Mountain View Electric Association, Inc. (MVEA) has these comments about the following:

Project Name: Bent Grass Residential, Filing 2

Project Number: SF 1914

LOCATED IN THE NORTHWEST QUARTER AND SOUTHWEST QUARTER OF  
SECTION 1 T13S R65W OF THE 6TH PRINCIPAL MERIDIAN  
COUNTY OF EL PASO, STATE OF COLORADO  
PROPOSED LOTS, TRACTS AND EASEMENTS MAP

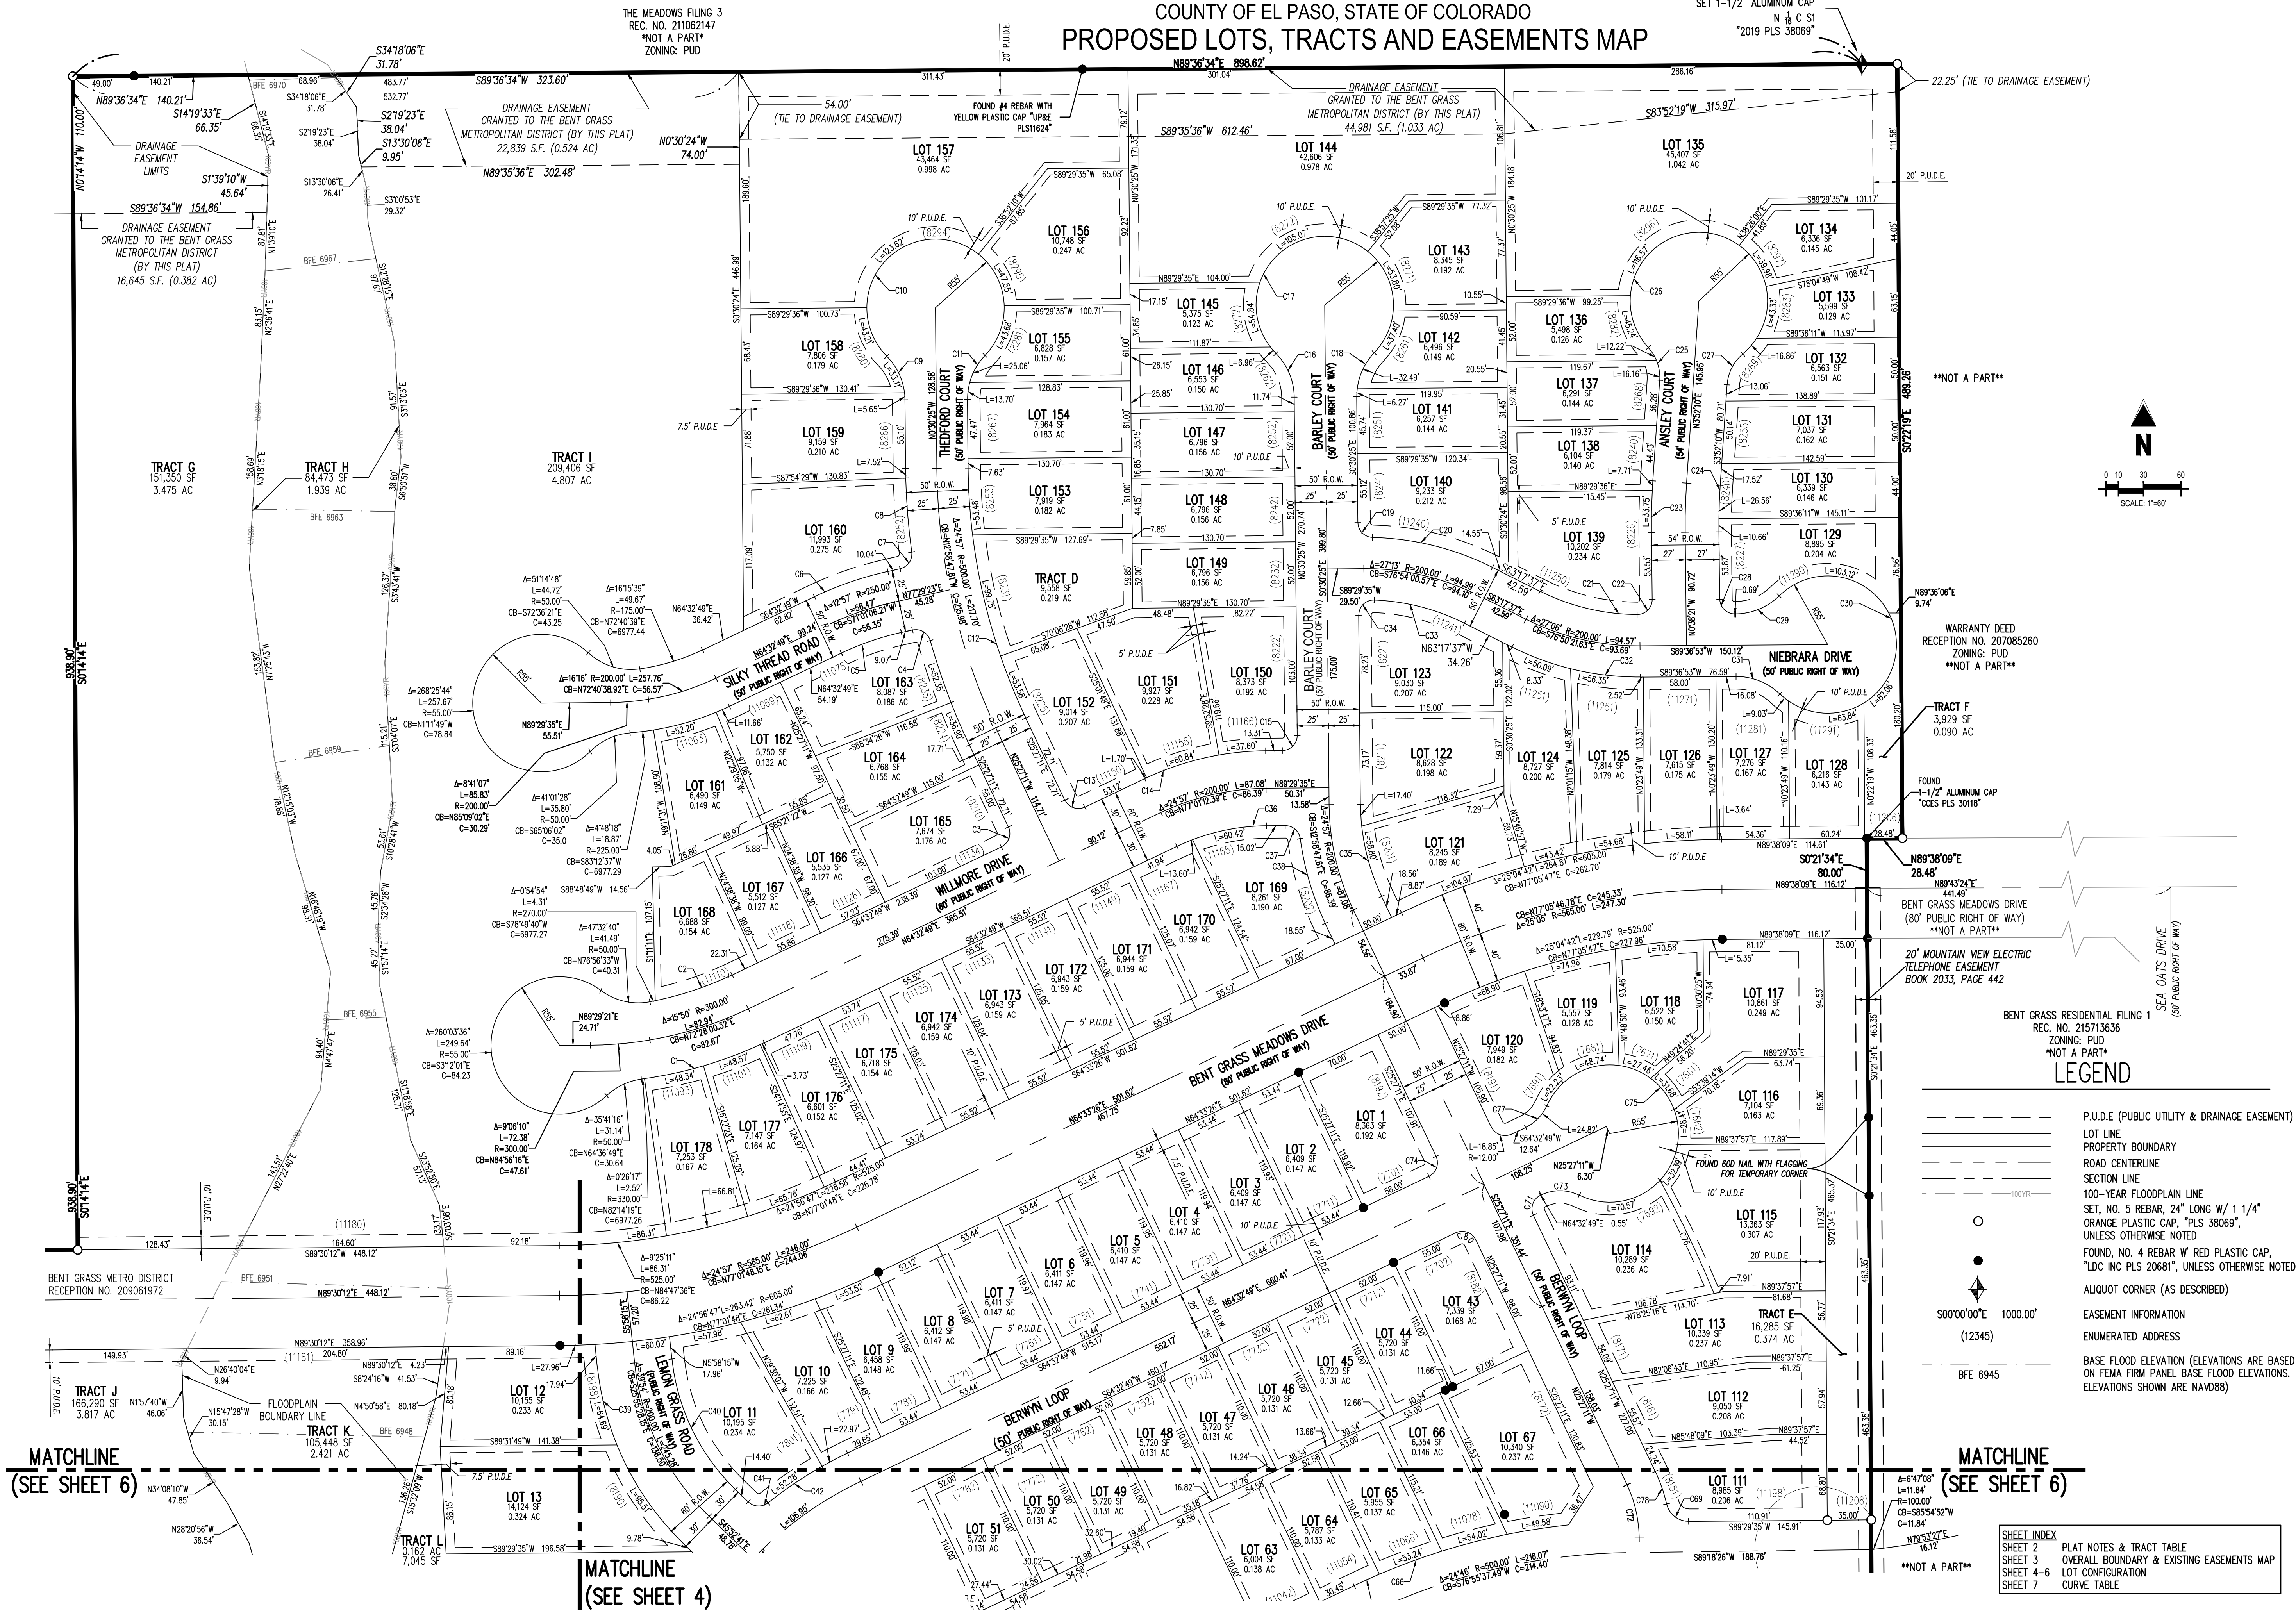
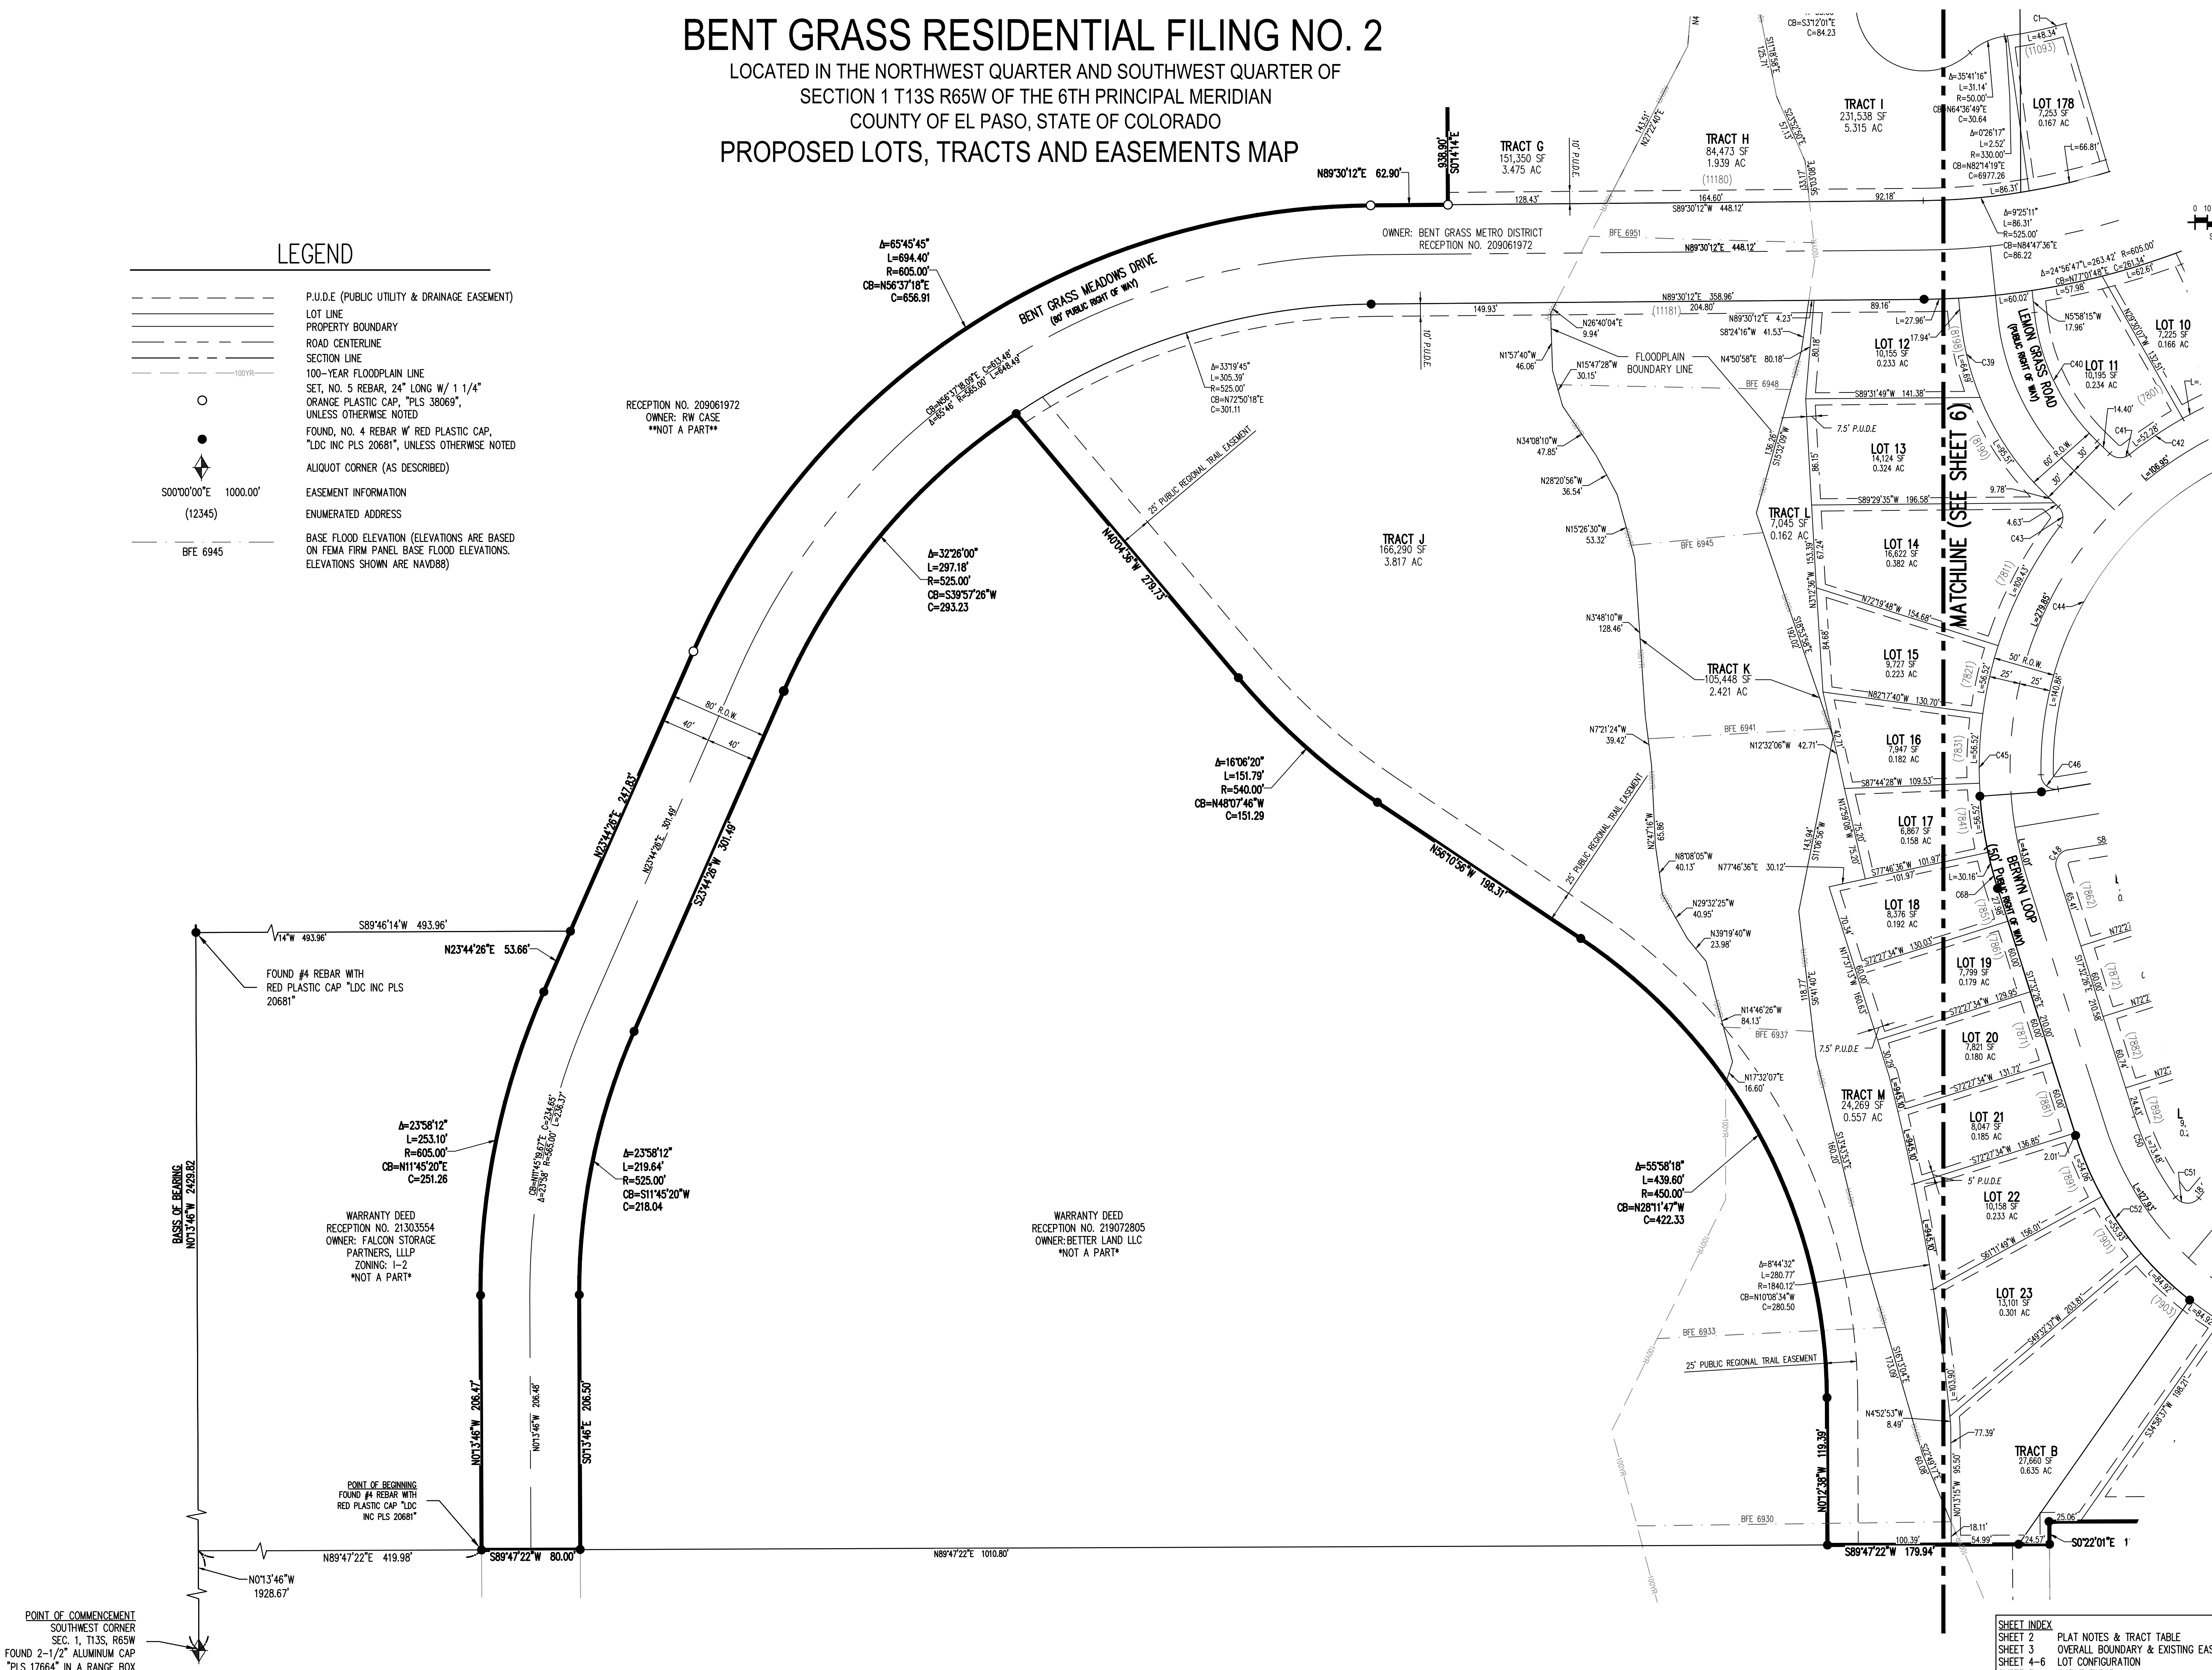
MVEA requests a seven & half (7.5) rear lot utility easement, five (5) foot side lot utility easement, and ten (10) front lot line utility easement along with a twenty (20) foot exterior utility easement on plat. MVEA also requests platting of existing MVEA facilities with easement on the plat. If open space, drainage and landscape tracts are designed in this subdivision MVEA requests these areas be listed to include utilities. Additional easements may be required once a review of civil drawings with grading and erosion plan is provided to MVEA in order to serve this subdivision.
